Our ref: HA/2009/107506/01-L01
Your ref: LU/190/09
Date: 12 August 2009

PROPOSAL TO CONVERT A REDUNDANT COASTGUARD TOWER TO A RESIDENTIAL PROPERTY

LITTLEHAMPTON COASTGUARD TOWER

Environment Agency position

SITE PLAN - SCALE 1:200

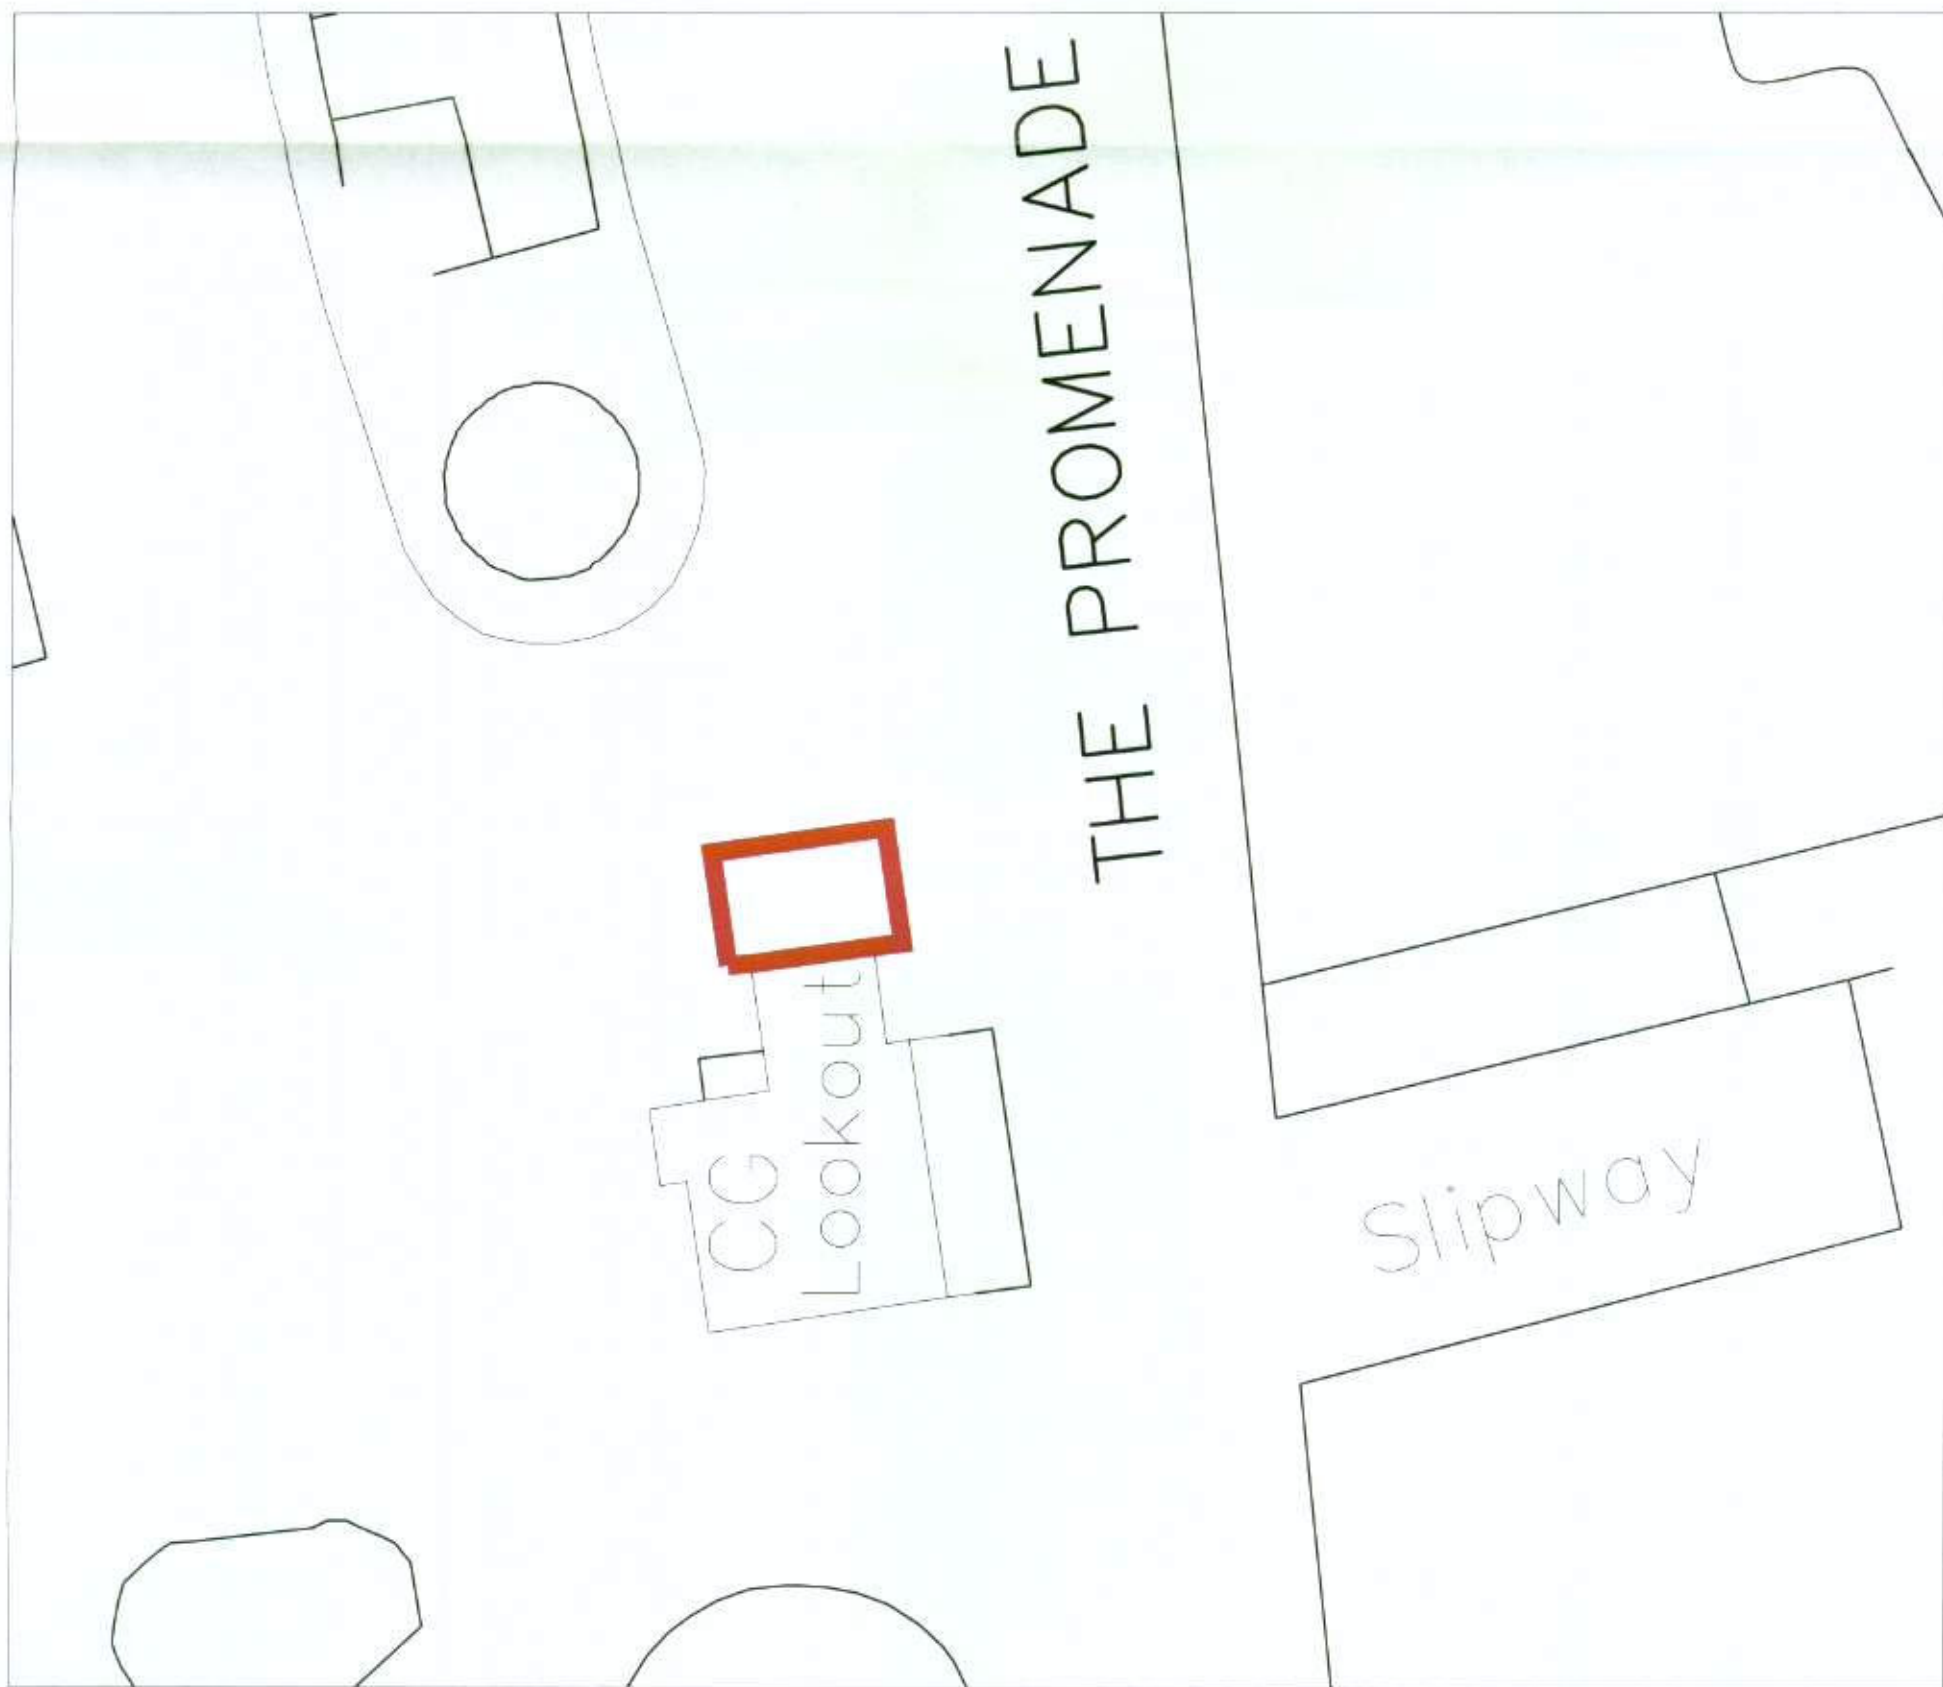
In particular, the submitted FRA fails to adequately consider safe access/egress. It identifies a safe route from the site heading north towards South Terrace. The ground levels decrease in this direction and so the depth of flooding in would not fit into the 'safe for all' cells of table 13.1 of TR2/FD2320. We also do not consider access along the beach front to be safe during extreme storm conditions.
